Engineers Comments Regarding Surface Water Drainage

Application Reference:	BR/82/26/PL	Reviewer Reference:	ADC/EXT5/AF
Planning Officer:	Amber Willard	Date of Review:	16/07/2026
Site Name:	63 Annandale Avenue Bognor Regis PO21 2ET		
Application Description:	Demolition of the existing dwellinghouse and associated buildings, and the construction of a three-storey building comprising 9 No. self-contained flats with associated landscaping, refuse storage, bicycle storage and parking spaces. This application is in CIL Zone 4 (Zero Rated) as other development.		
Assessment Number:	1

CONTRIBUTING AREA PLAN (1:200)

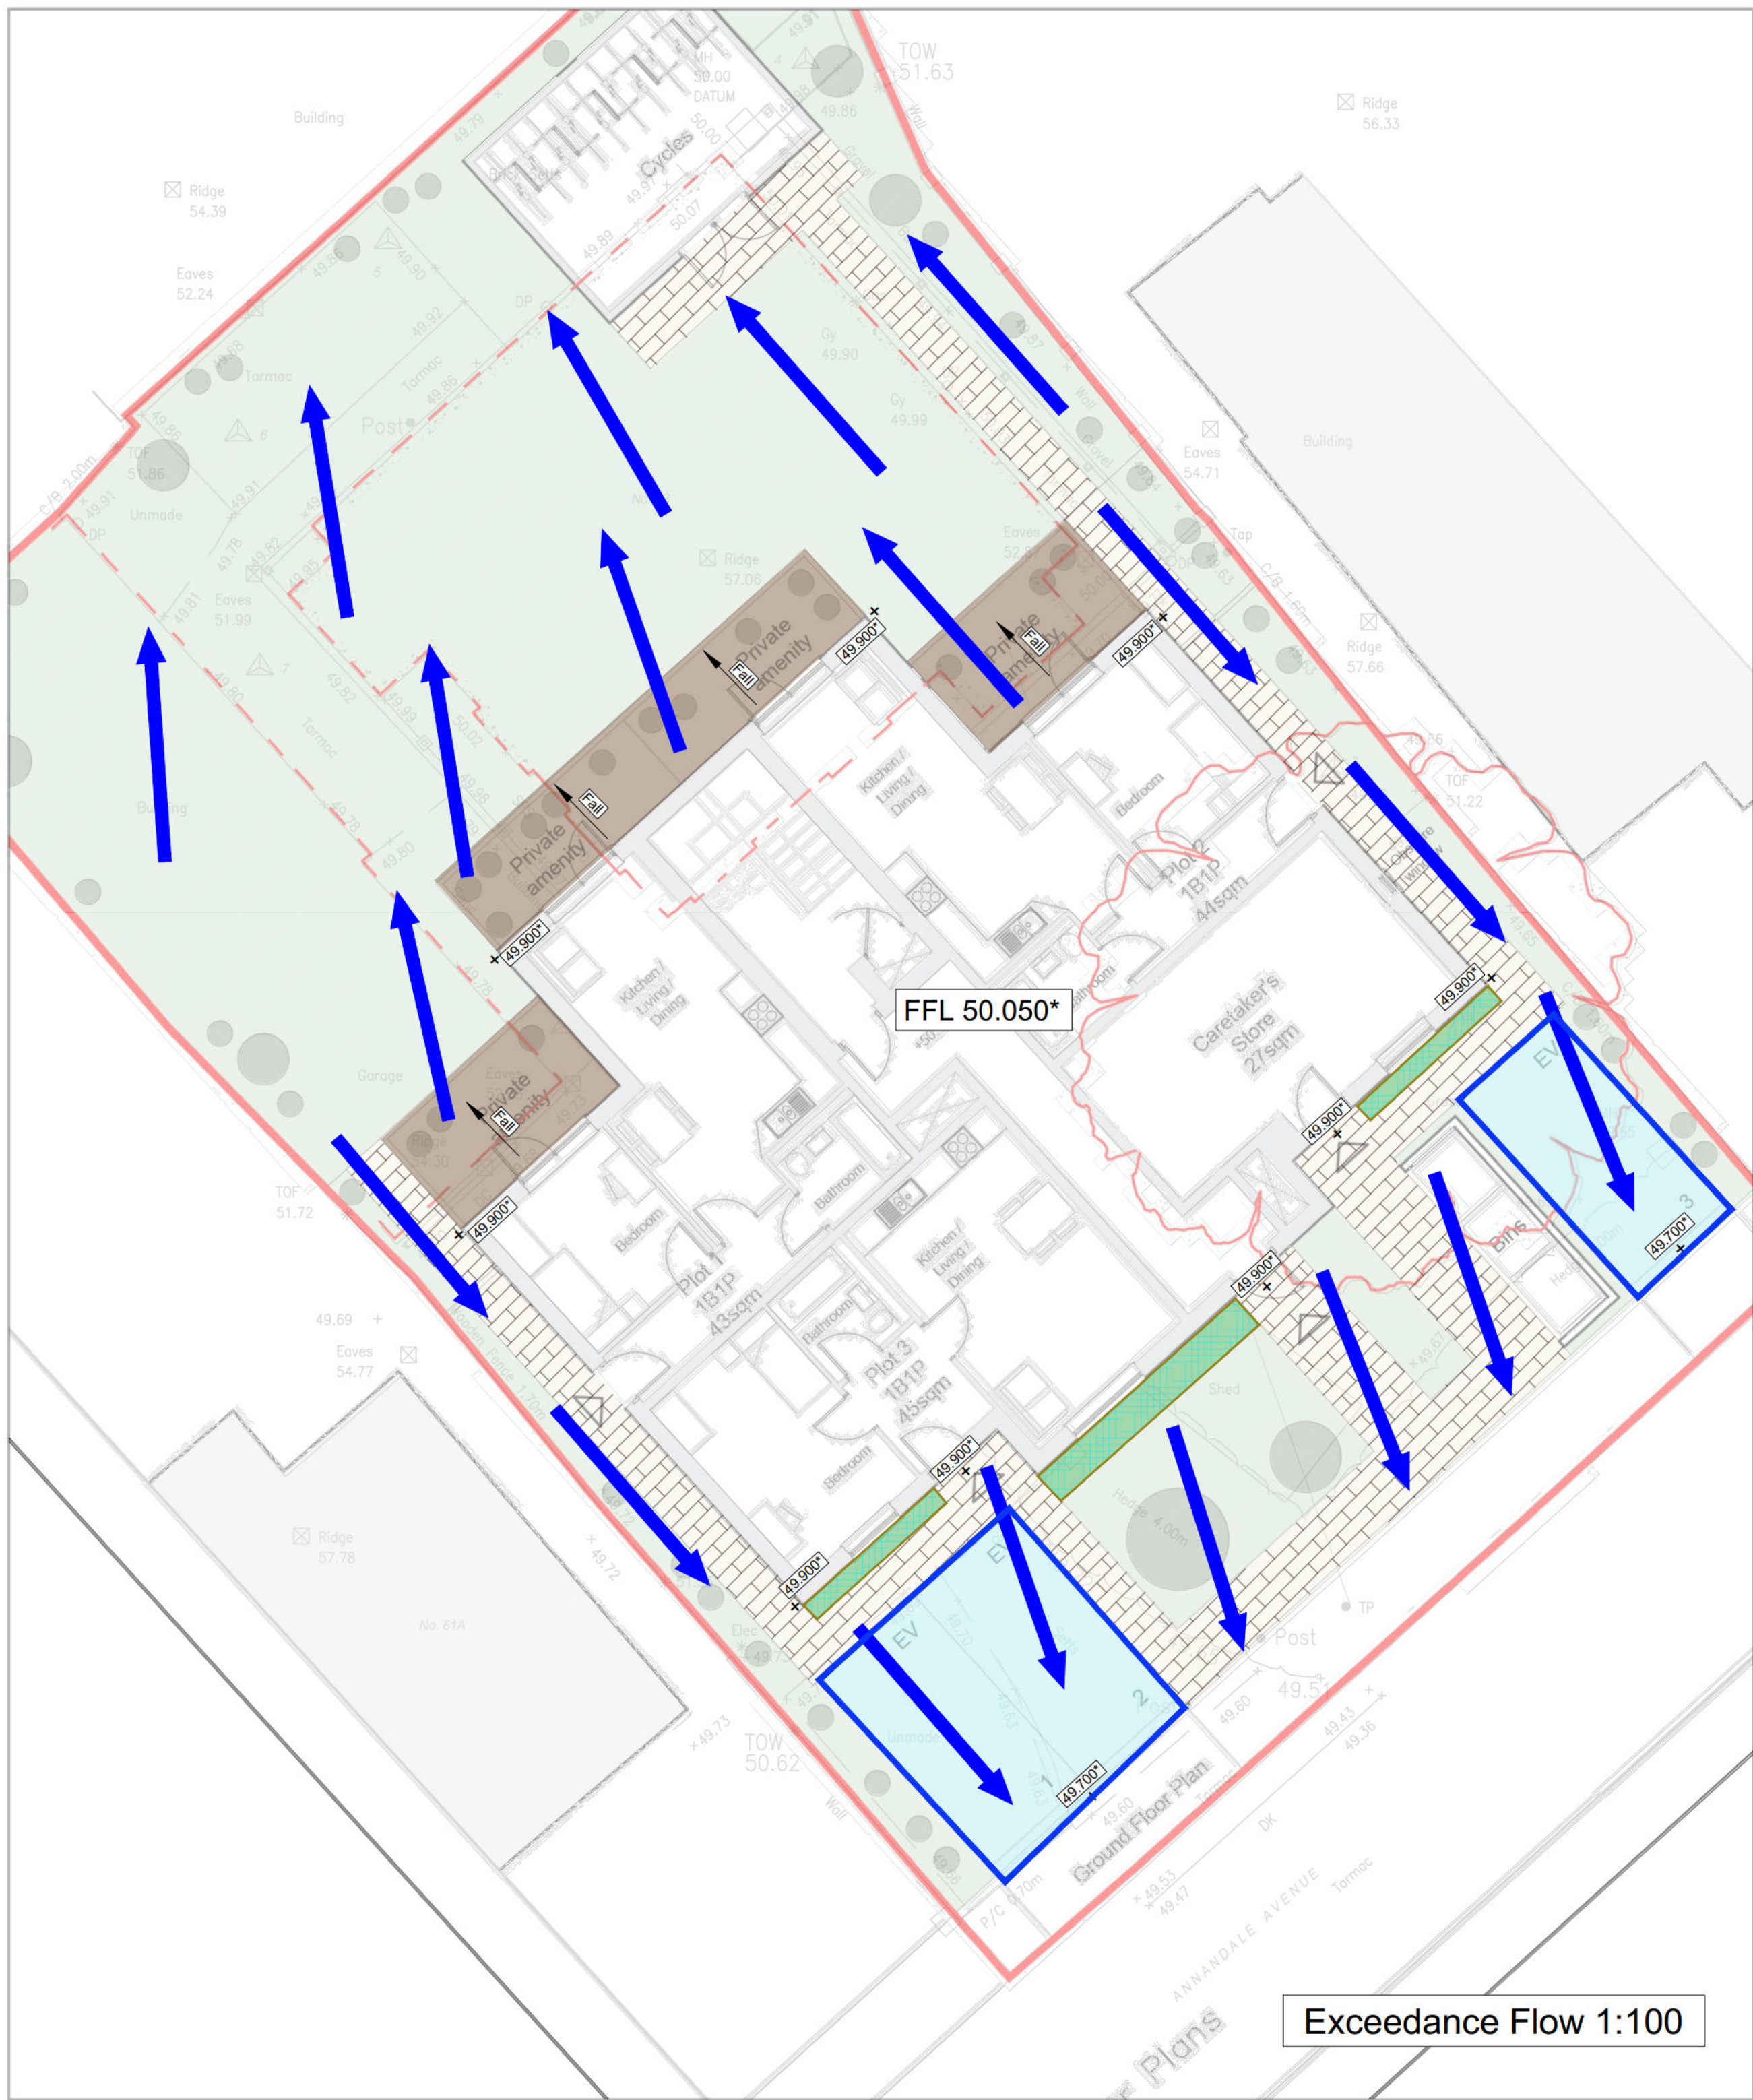
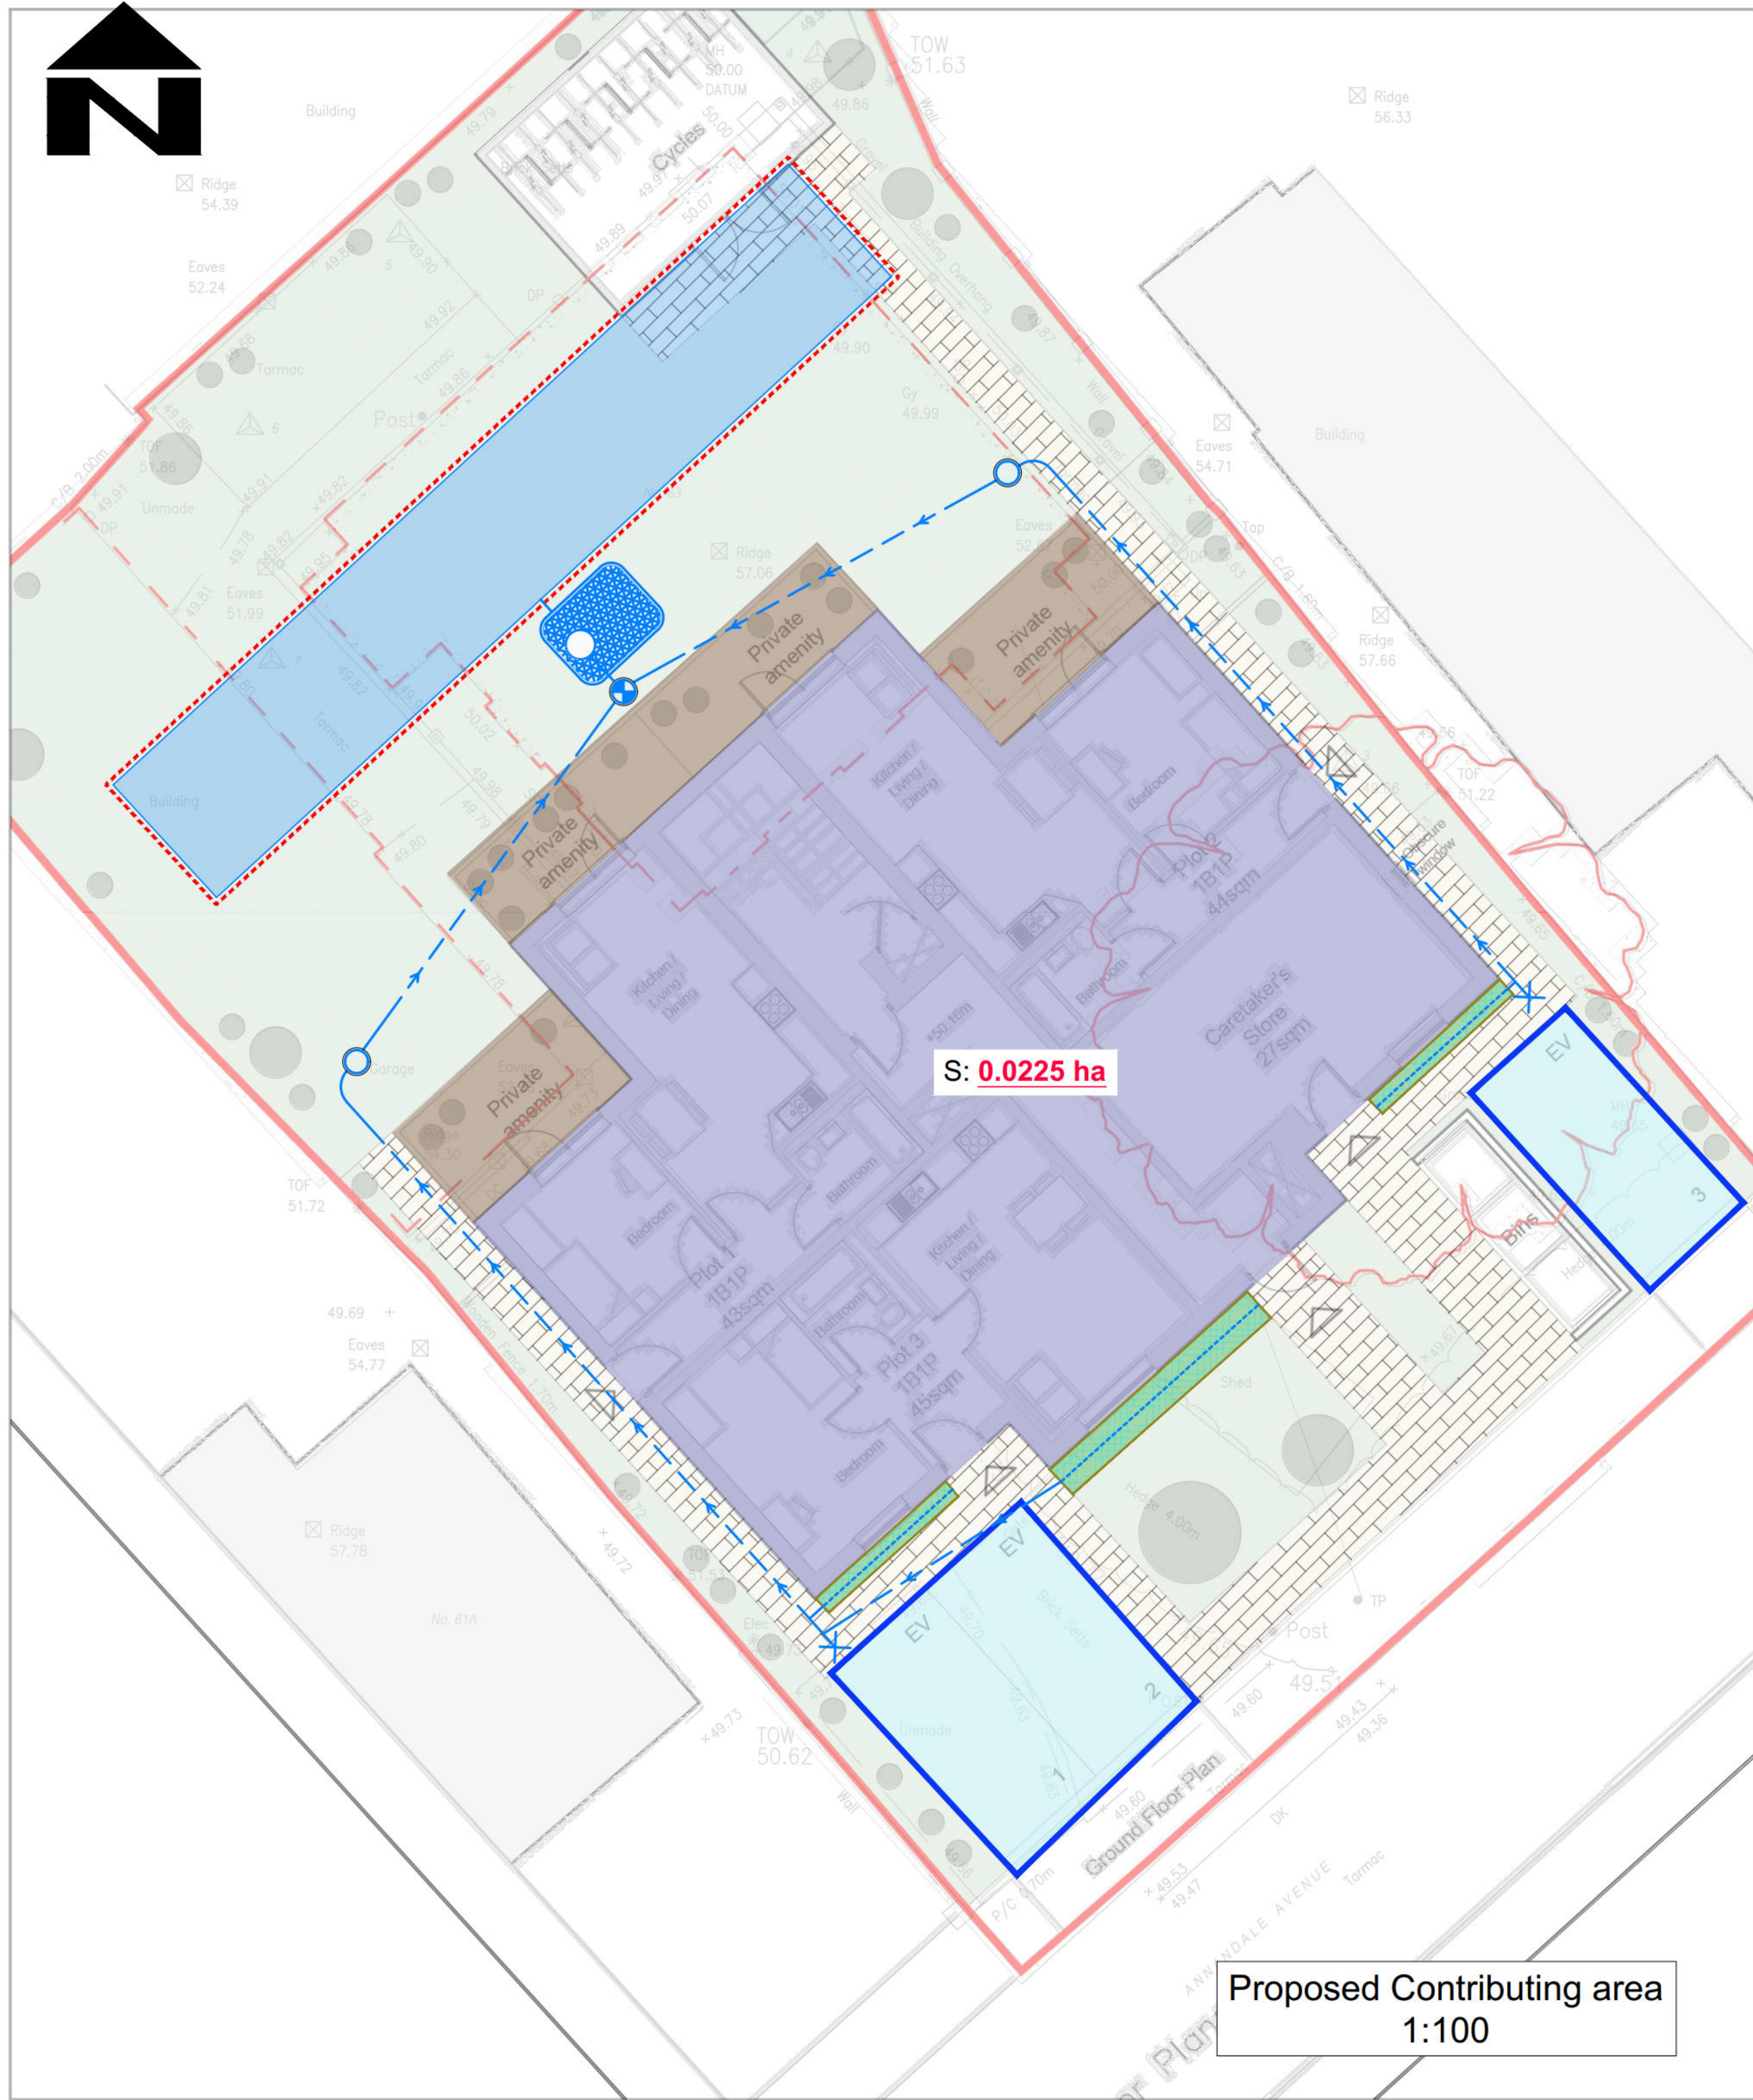
- 3.3. The drained areas do not match the calculations. The drained areas plan shows 265 sqm or 0.027 ha whereas the calculations show 0.024 ha. This may be due to rounding but the calculations should be robust and it is not clear from the numbers that urban creep has been incorporated. The drained area into PP1 is shows as 20 sqm in the calculations and 40 sqm on the drained areas plan. The calculations and plan should be clarified and revised as necessary.

- 3.4. Calculations are not provided for the patio areas – PP2.
- 3.5. Further information is required to confirm the design is in accordance with the requirements of the NSfS (Standard 3). Therefore, we **object** to the application.
